LSC Response - Estates Rolling Hills Ranch Fil No 2 TIA Redlines

[Add PCD File No. PUDSP204 & SF2018](#)

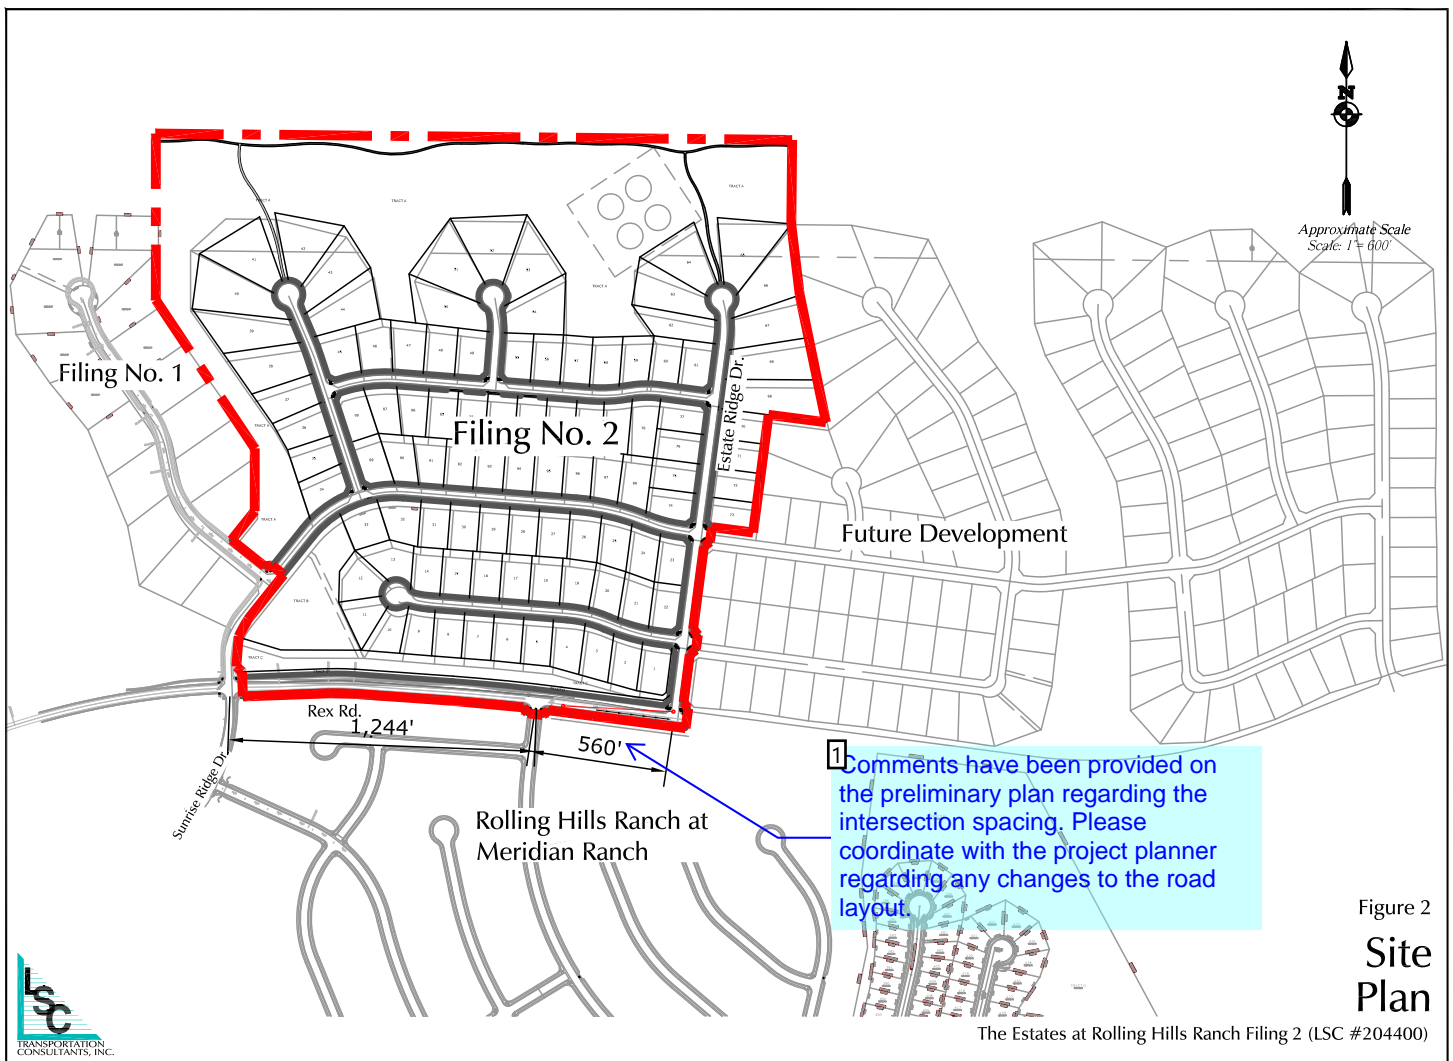
☰ Author: Daniel Torres Subject: Callout Date: 9/1/2020 1:50:38 PM

Estate Ridge Drive

↩ Author: Kirstin Subject: Sticky Note Date: 10/7/2020 11:40:23 AM
revised as requested

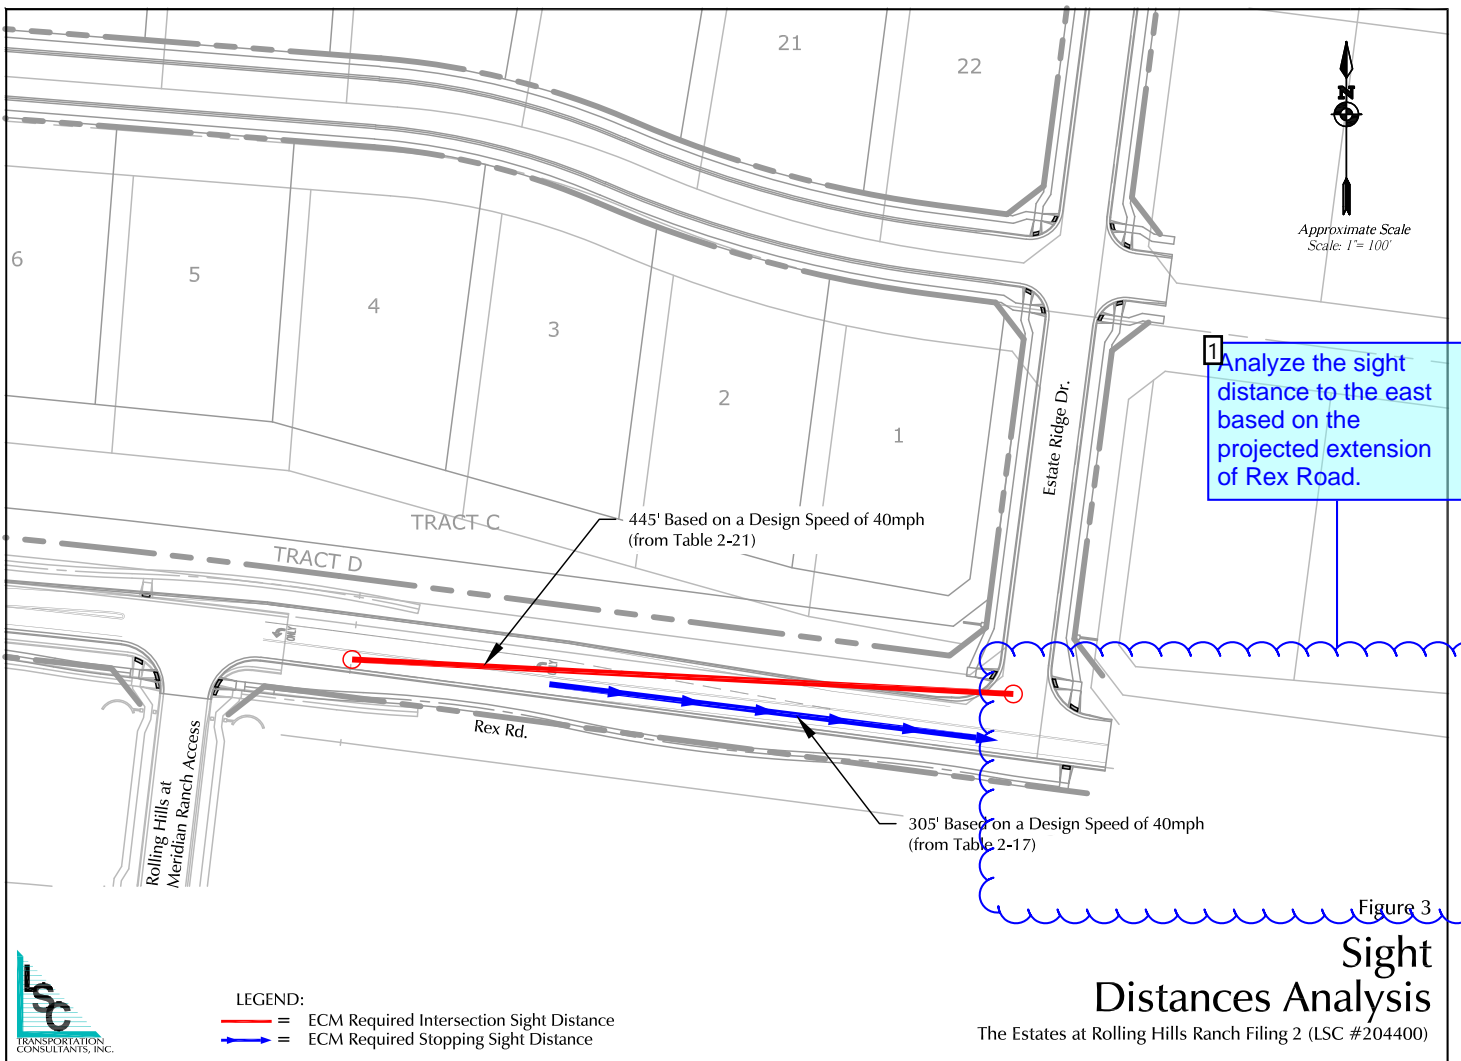
Author: Daniel Torres Subject: Callout Date: 9/2/2020 6:05:07 PM

Comments have been provided on the preliminary plan regarding the intersection spacing. Please coordinate with the project planner regarding any changes to the road layout.

Author: Kirstin Subject: Sticky Note Date: 9/29/2020 3:21:17 PM
It is our understanding that the intersection spacing has been approved

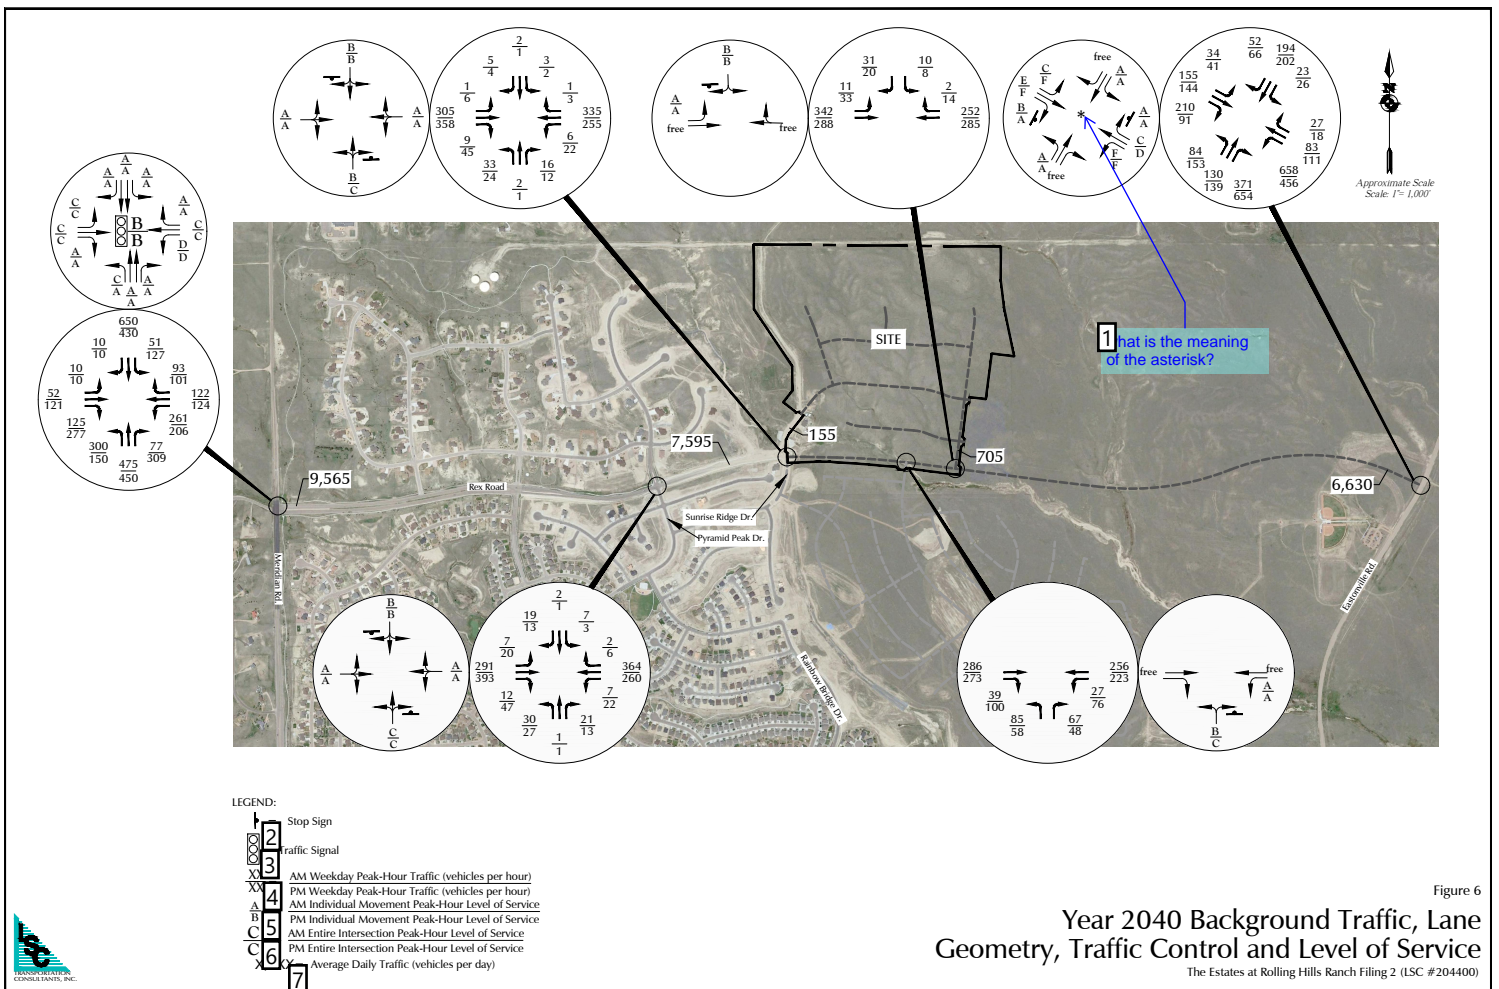
Author: Daniel Torres Subject: Cloud+ Date: 9/1/2020 2:05:42 PM

Analyze the sight distance to the east based on the projected extension of Rex Road.

Author: Kirstin Subject: Sticky Note Date: 9/29/2020 3:21:55 PM

The additional analysis has been included in the updated TIA as requested

Figure 7

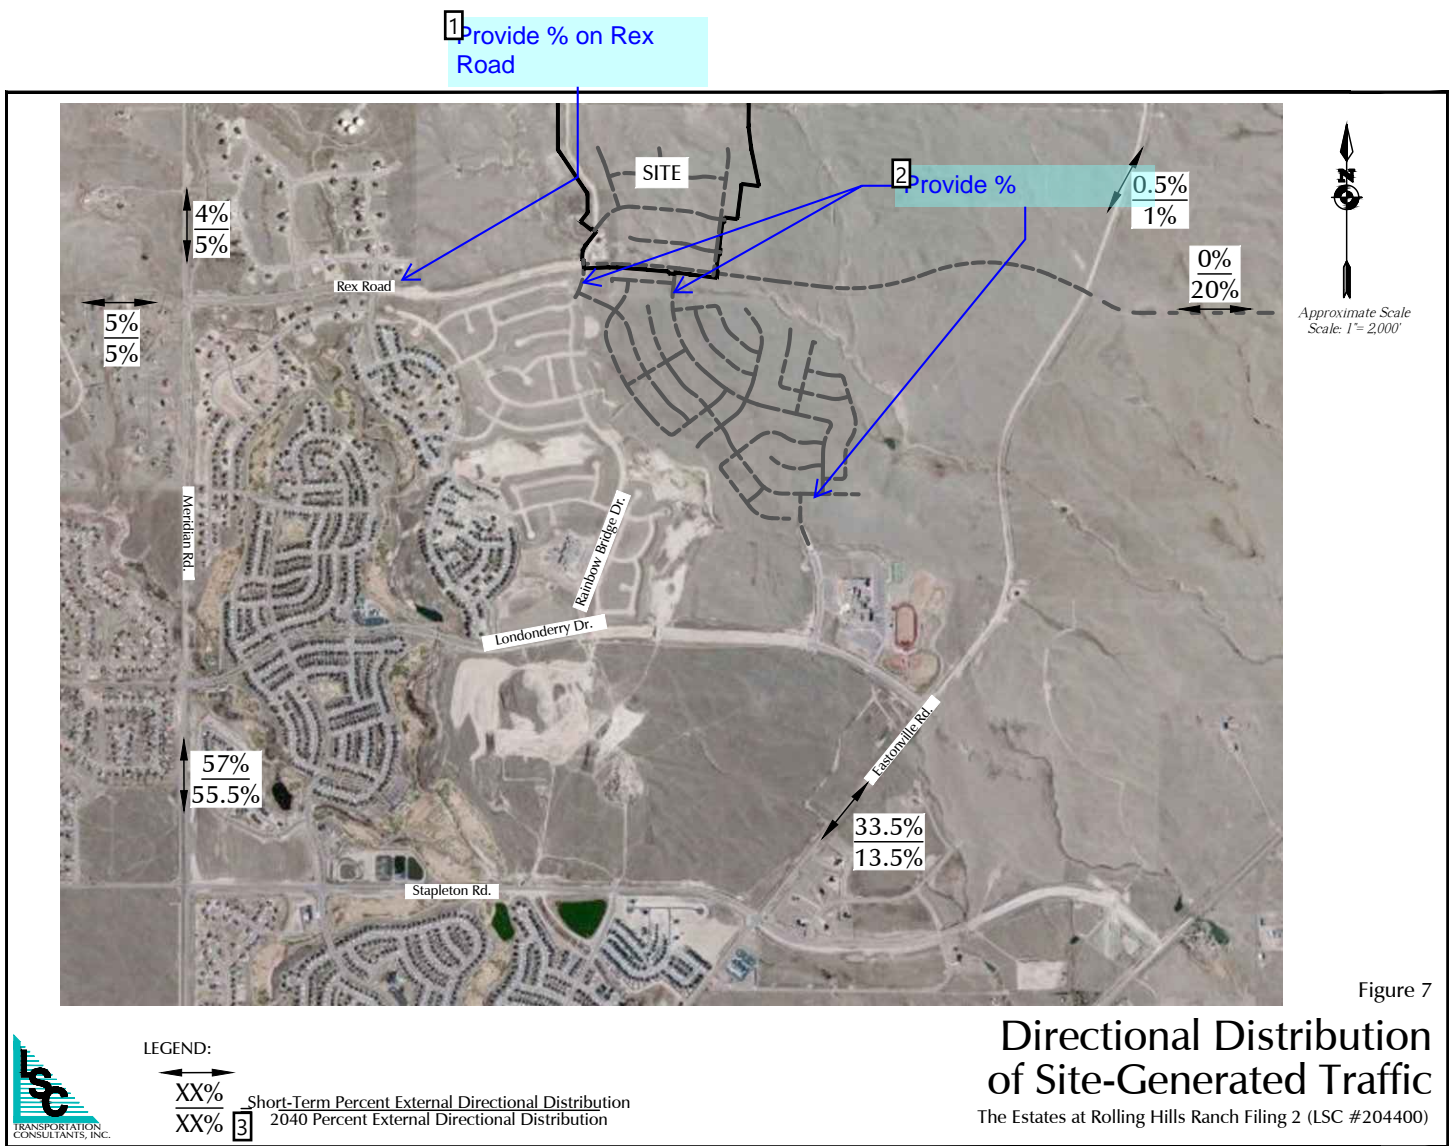
Author: Daniel Torres Subject: Callout Date: 9/1/2020 3:41:15 PM

[Provide % on Rex Road](#)

Author: Kirstin Subject: Sticky Note Date: 9/29/2020 4:10:37 PM
The requested information has been added to the updated TIA
